Rezoning Transportation Analysis

Petition Number: 2022-121

Revision Log:	Date	Description
	01-25-23	First Review (PDM)

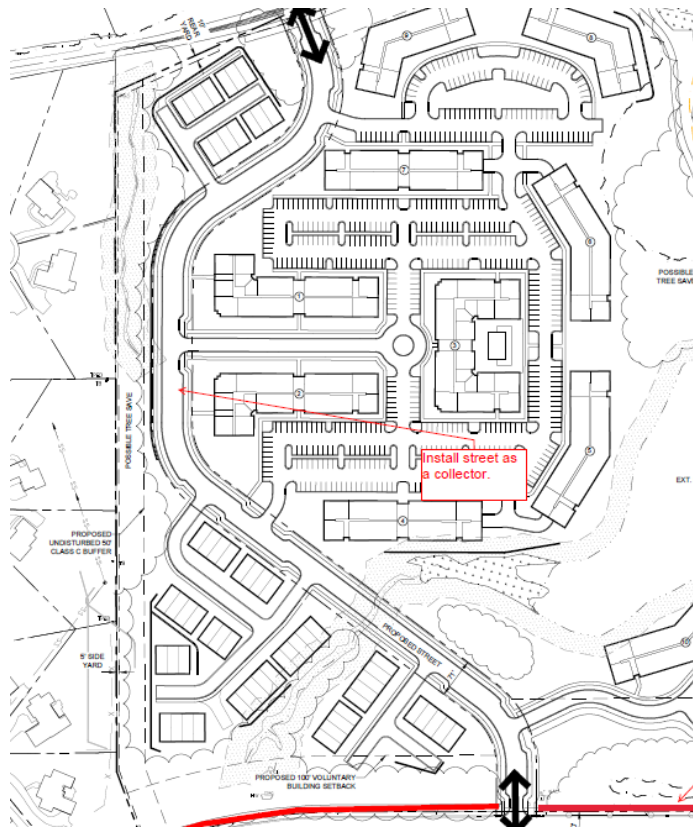
2. Revise site plan and conditional note(s) to commit to dedicate 35-feet of right-of-way from the road centerline of Elm Lane. The site plan shall label and dimension the right-of-way from the road centerline.
3. Revise site plan and conditional note(s) to commit to construct bicycle facilities by installing a 12' multi-use path along Rea Road to meet the Council-adopted Charlotte BIKES Policy. Multi-use paths maintained by the City shall meet ADA/PROWAG requirements. The multi-use path should provide a public onsite connection to the greenway. In addition, commit to providing public access easements for the onsite MUP connections along Rea Road and Elm Lane. For multi-use paths along the public streets, provide sidewalk utility easement located 2ft at back of path if located outside of the right-of-way. Reconcile these improvements with conditional note 6.C

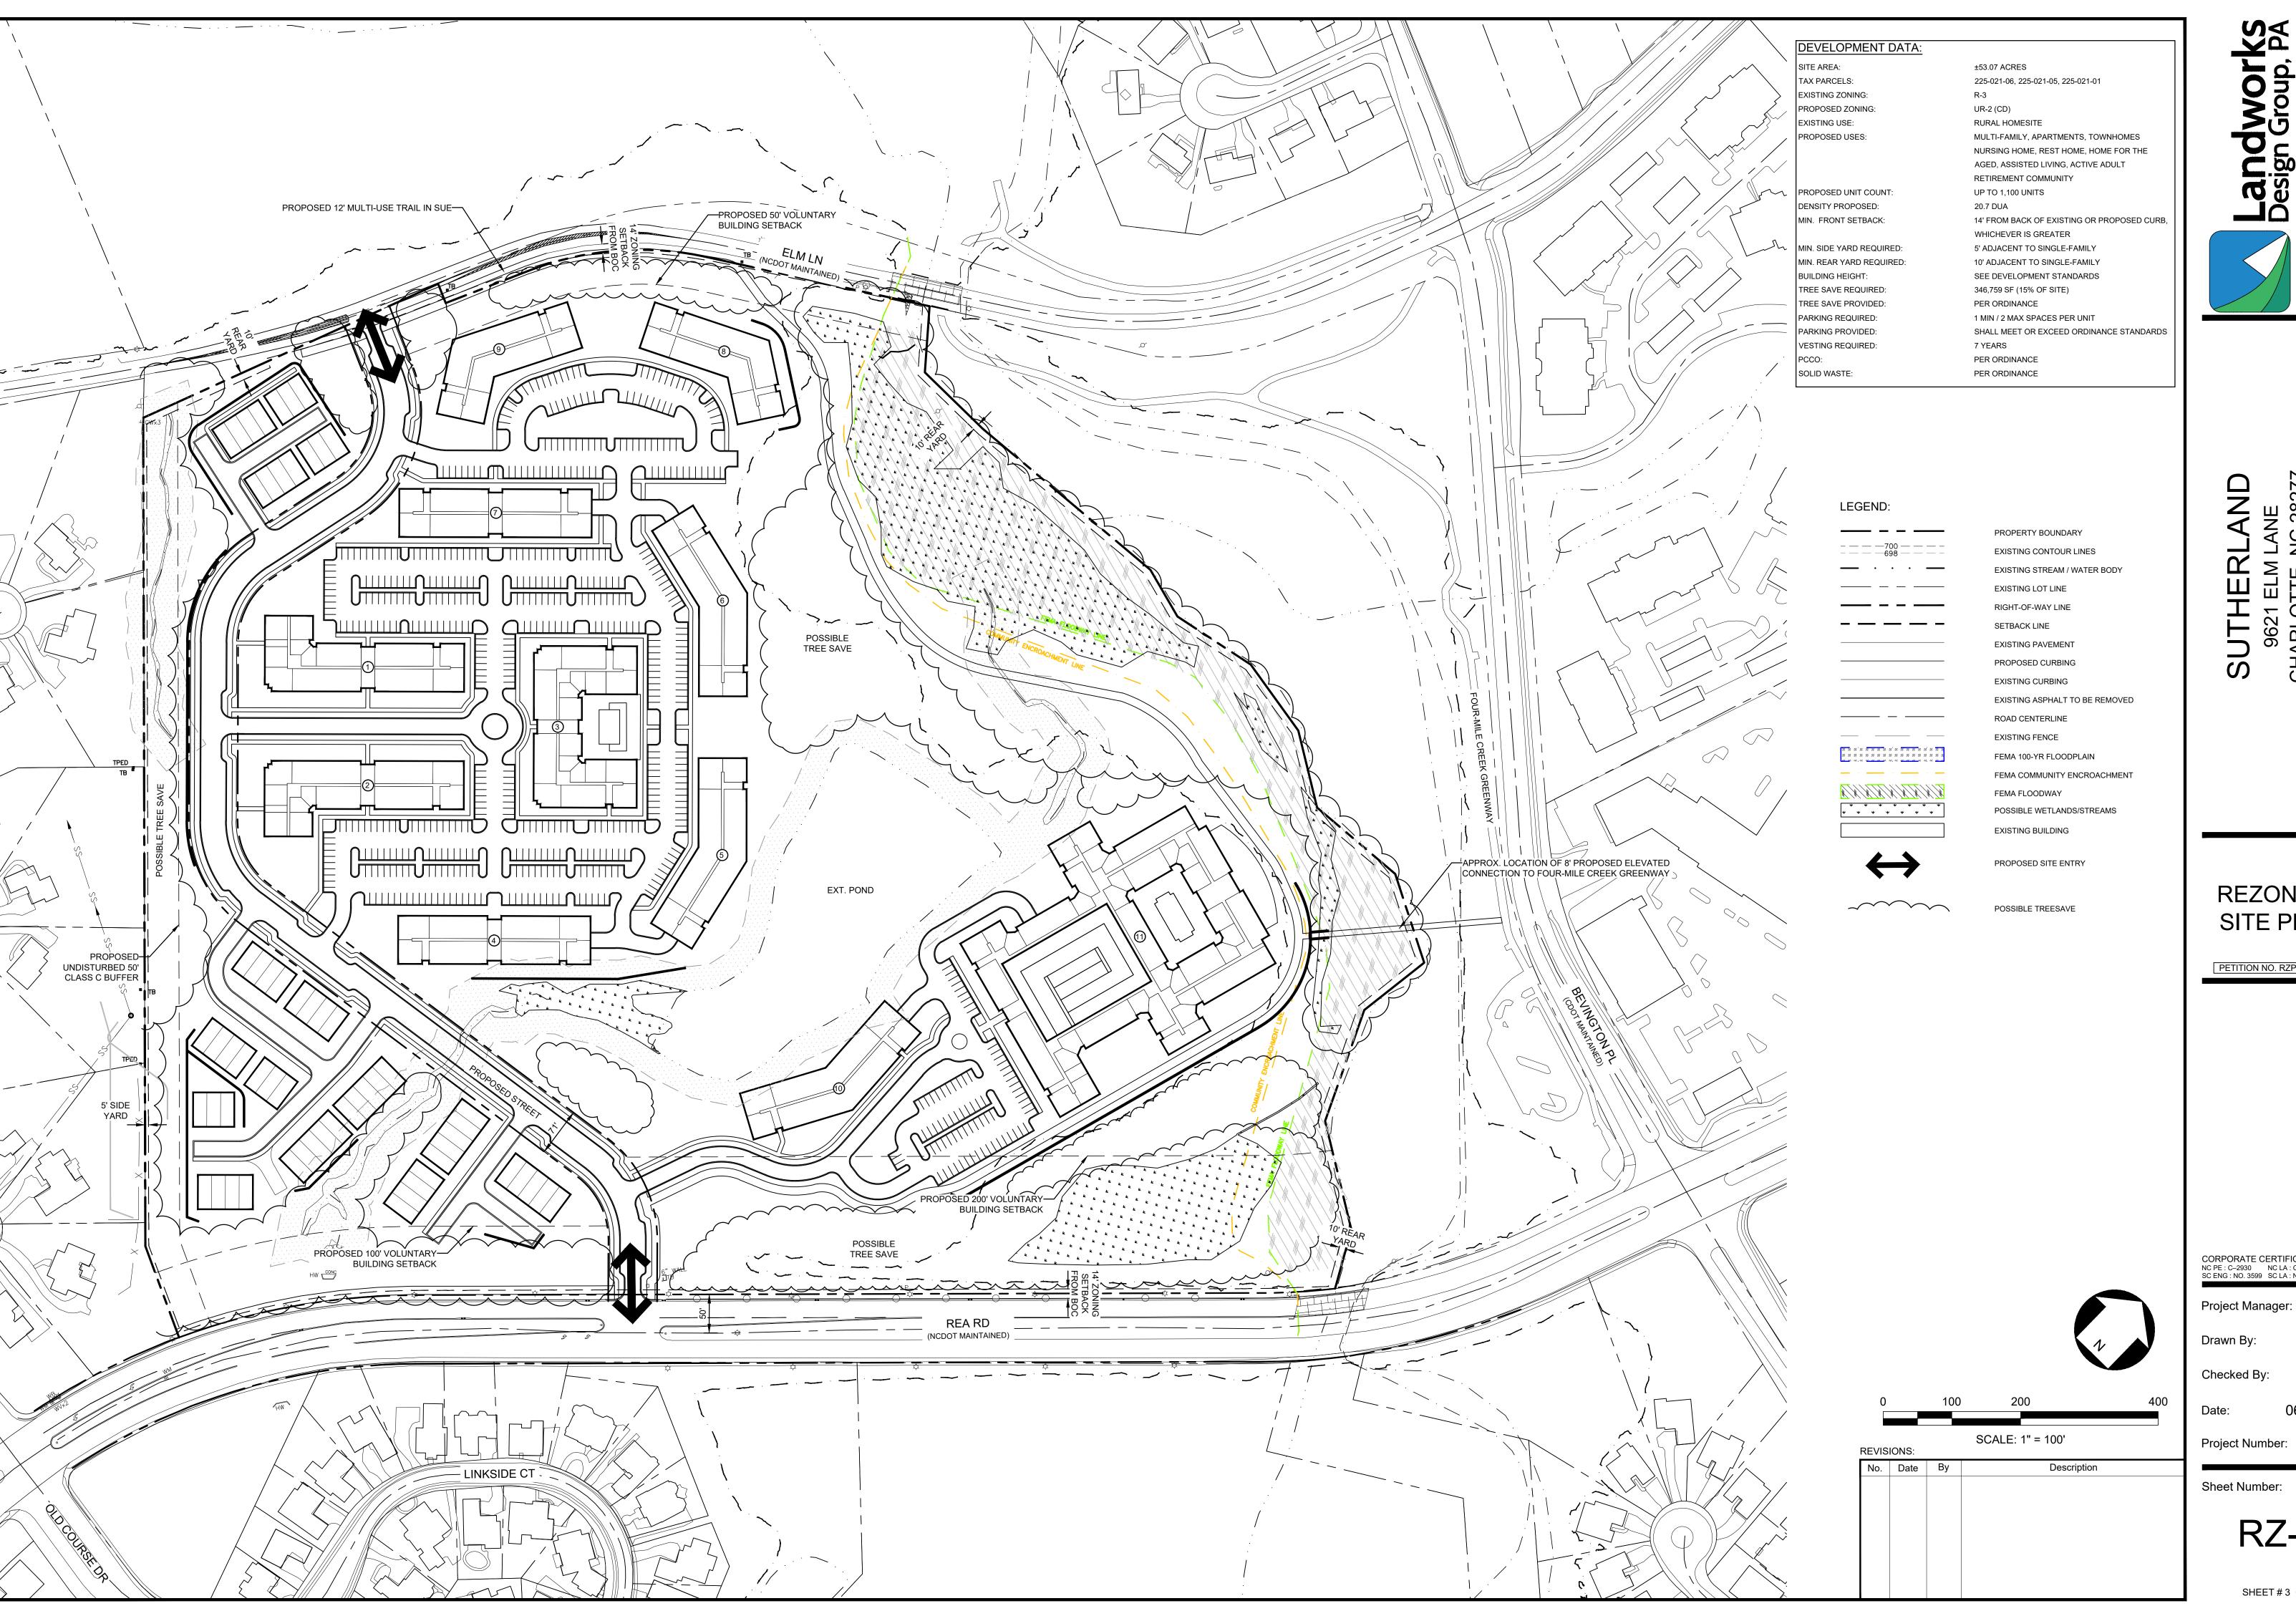
6. Add a conditional note specifying “the Petitioner shall dedicate and convey in fee simple all rights-of-way to the City before the site’s first building certificate of occupancy is issued. CDOT requests rights-of-way set at 2’ behind back of sidewalk where feasible.”

7. Add a conditional note specifying “All transportation improvements will be approved and constructed before the site’s first building certificate of occupancy is issued. The petitioner may phase transportation improvements if said improvements and phasing are explicitly described in site plan notes.”

8. Add conditional note specifying “All public roadway improvements will be subject to the standards and criteria of CDOT and NCDOT, as applicable, to the roadway improvements within their respective road system authority. It is understood that such improvements may be undertaken by the Petitioner on its own or in conjunction with other development or roadway projects taking place within the broad south Mecklenburg area, by way of a private/public partnership effort or other public sector project support.”
